**Consultation Response from
 KC Waste Strategy (Refuse & Cleansing)**

PA no. & address: 2020/92331 Land east of, Leeds Road, Chidswell, Shaw Cross, Dewsbury

Proposal: Outline planning application for demolition of existing dwellings and development of phased, mixed use scheme comprising residential development (up to 1,354 dwellings), employment development (up to 35 hectares of B1(part a and c), B2, B8 uses), residential institution (C2) development (up to 1 hectare), a local centre (comprising A1/A2/A3/A4/A5/D1/D2 uses), a 2 form entry primary school including early years provision, green space, access and other associated infrastructure

Date Responded: 21/08/2020	Responding Officer: Carol Oakden	Responding Ref: WPN-20-044
--------------------------------------	--	--------------------------------------

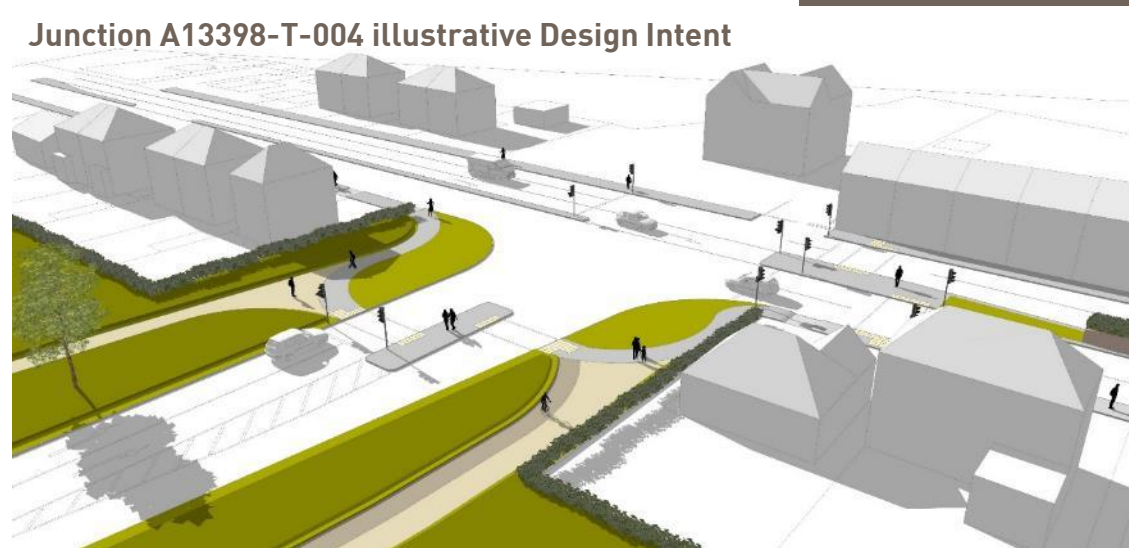
- Cul-de-sac road layouts must be avoided to reduce the need to reverse an RCV. The concept layout shows multiple looped road layouts which is welcomed provided it can be demonstrated (by swept path analysis) that an 11.85m refuse collection vehicle can safely manoeuvre into/out of the access points and around all turnings. Looped road layouts should be pursued through to detailed design should the outline application be approved. Legislative changes coupled with housing growth will put pressure on the Council to utilise bigger, more efficient vehicles and the need to accommodate these safely, with minimal reversing is vital.
